Project Name : Bilsham Road, Yapton

Job No : 19-326

Note Title : Drainage Strategy Addendum No. 1

1.1.2 The proposed drainage strategy was submitted to Arun District Council (ADC) in January 2021 as part of planning application Y/3/21/DOC.

BILSHAM ROAD, YAPTON			
Drawing Title: PRELIMINARY ENGINEERING LAYOUT. SHEET 2 OF 2			
Client: BILSHAM ROAD DEVELOPMENT LLP			
Scale: 1:500 @A0	Date: FEB 20	Designed: NA	
Drawn: LS	Checked: JH	Approved: GG	
Job No: 19-326	Drawing No: 19-326/010	Rev: J

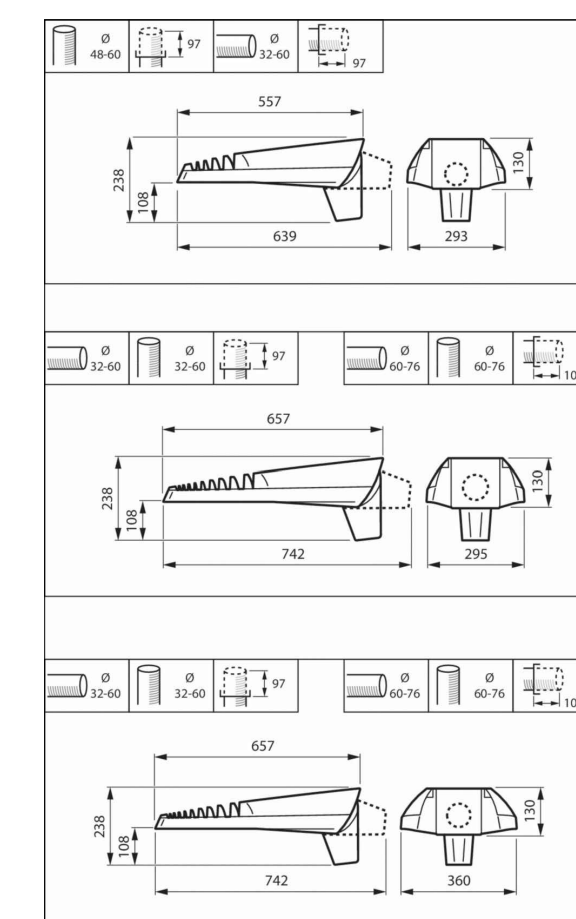
“Groundwater monitoring results must be provided and should be overlaid on detailed drainage layout drawings.”

“All pipes must be labelled with diameters and falls.”

“Manhole invert and cover levels must be provided.”

“A detailed review of calculations has not yet been undertaken due to the above. Please ensure that pipe reference numbers are included on layouts to facilitate review.”

“Note to be added to drawing to state that watercourses will be cleared of vegetation and silt as part of works. These works must be completed near the beginning of construction to ensure the free flow of water.”

2.1.3 The results of groundwater monitoring are provided in **Drawings 19-326/009 and 19-326/010** in **Appendix B**.

2.1.4 The diameters of the proposed pipes were included in the submitted drainage strategy drawings. The falls have been added to show the gradient of the pipes, and are shown in **Appendix B**.

2.1.5 The invert and cover levels of the proposed manholes are shown in **Appendix B**.

2.1.16 The reference numbers of the proposed pipes have been added to the drainage strategy drawings and are shown in **Appendix B**.

2.1.24 A note detailing the works to the watercourses has been added to the drawings in **Appendix B**.
